2002-0234
Application I. D. Number
10/29/2002
Application Date
1 2-story 4-unit building (lot 2)
Project Name/Description

RE: Maggie Lane Subdivision
Lots 1 & 2 – Forest Avenue

Gorrill-Palmer Consulting Engineers, Inc. is pleased to respond to the review comments we received in an e-mail from Jim Seymour at Sebago Technics, regarding the above referenced project. For ease of review, each of the comments are repeated below followed by our response.

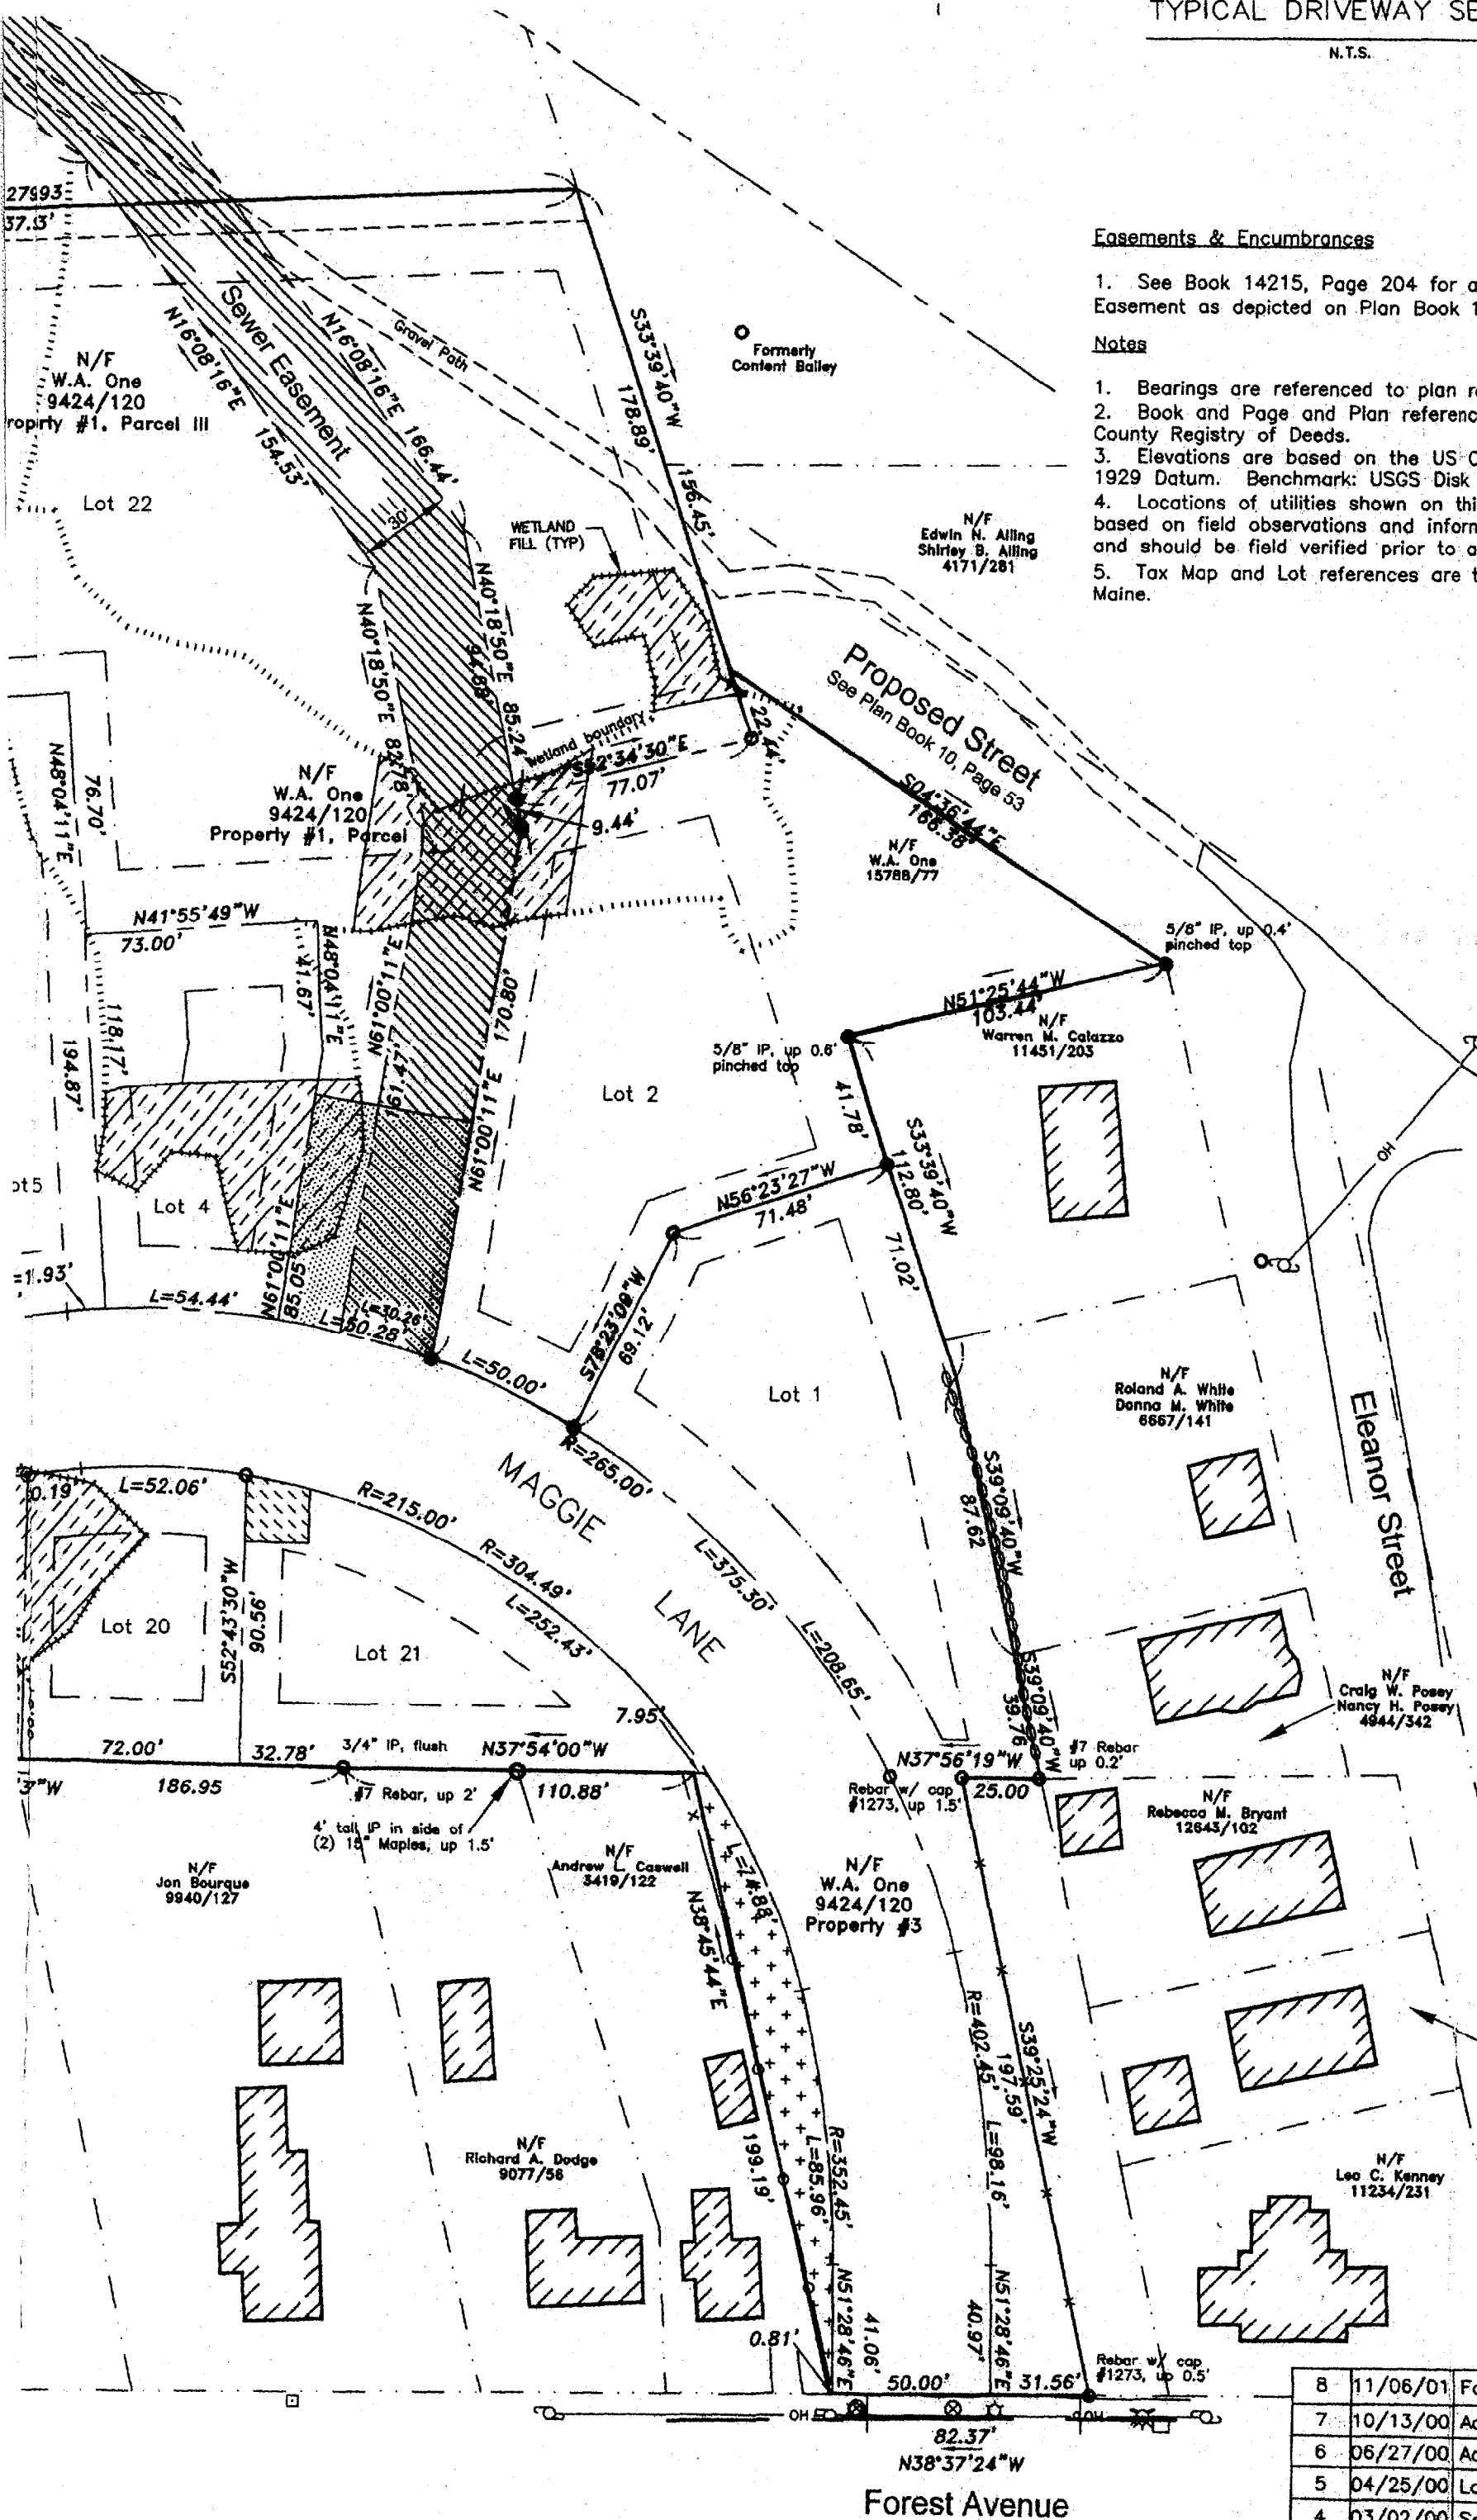
Comment 3A - Locate/stake property line prior to construction along top of drawing where proposed drainage ditch runs between the proposed wall and property line to prevent grading being carried over the property line.

Comment 3B - Show appropriate BMP measures on plans.

Comment 3C - Is any filling of wetlands proposed at the rear of the 4-unit multiplex? Both existing and proposed grades should be provided on the plans. What are the proposed grades at the building (basement FFE) relative to existing/proposed yard elevations/grades.

Comment 3D - The driveway culvert should include riprap inlet/outlet aprons.

Comment 3E - All ditches must be stabilized.

Comment 4A - The existing catch basin and stormdrain infrastructure located up gradient of the driveway curb cut on Maggie Lane should be shown on the appropriate plans.

Comment 4C - Are foundation drains proposed for multiplex units or blast rock walls?

Comment 4D - We recommend that finished floor elevations be raised relative to sidewalk elevations. The Grading Plan indicates a 0.05' differential between the front edge of curb and F.F.E. Assuming the sidewalk will presumably have a cross slope of 1% to promote drainage, FFE will match the sidewalk grade. This is not an ideal situation.

Comment 4E - The area between the 3-unit multiplex and the proposed rock face should be ditched to promote better drainage.

Comment 4F - Show proposed electric services into site.

Comment 5C - Railings need to be installed along the tops of blast rock retaining walls due to elevation drops.

Comment 5E - The blast rock wall shall be designed by a geotechnical/structural engineer and stamped drawings provided prior to construction.

Comment 5J - Indicate proposed landscaping on the appropriate plan.

Response – A note has been added to the plan, which requires the contractor to stake or flag the rear property line, prior to clearing, as requested.

Response – Silt fence and stone check dams have been added to the plan as required.

Response – No additional wetland fills are required at the rear of the 4 unit building, whereas the portion of the building that is depicted adjacent to the wetlands is an elevated deck. Basement finished floor elevations have been added to the plan. The grades along the rear of the building have been spot graded as requested.

Response – Based upon conversation with City Staff, the roadside ditch, which is depicted on the grading plan does not exist in the field, therefore would not require a culvert under the proposed drive. The driveway culvert has been eliminated from the design.

Response – Stone check dams have been added to the plan to stabilize the ditches during construction. All ditches will be stabilized after construction with grass or another acceptable measure.

Response – The appropriated structures have been added to the plan.

Response – Locations of potential foundation drains have been added to the plans. It is noted that a basement drain for the four unit on Lot 2 would require pumping.

Response – The finished floor elevations have been raised as requested to remedy the situation.

Response – Spot grades have been clarified to depict a swale to promote drainage behind the three unit building.

Response – The approximate location of the existing transformer and potential electric services have been added to the plan.

Response – A railing has been added to the plan at the top of the steep slopes, as requested. The railing is intended to be a galvanized pipe railing.

Response – The blast rock walls have been revised to have approximately 1:1 slopes rather than be a vertical wall constructed of blasted material. A 1:1 rock slope has been used and approved by the City on other lots on this site.

Response – Landscaping has been added to the plan as required.
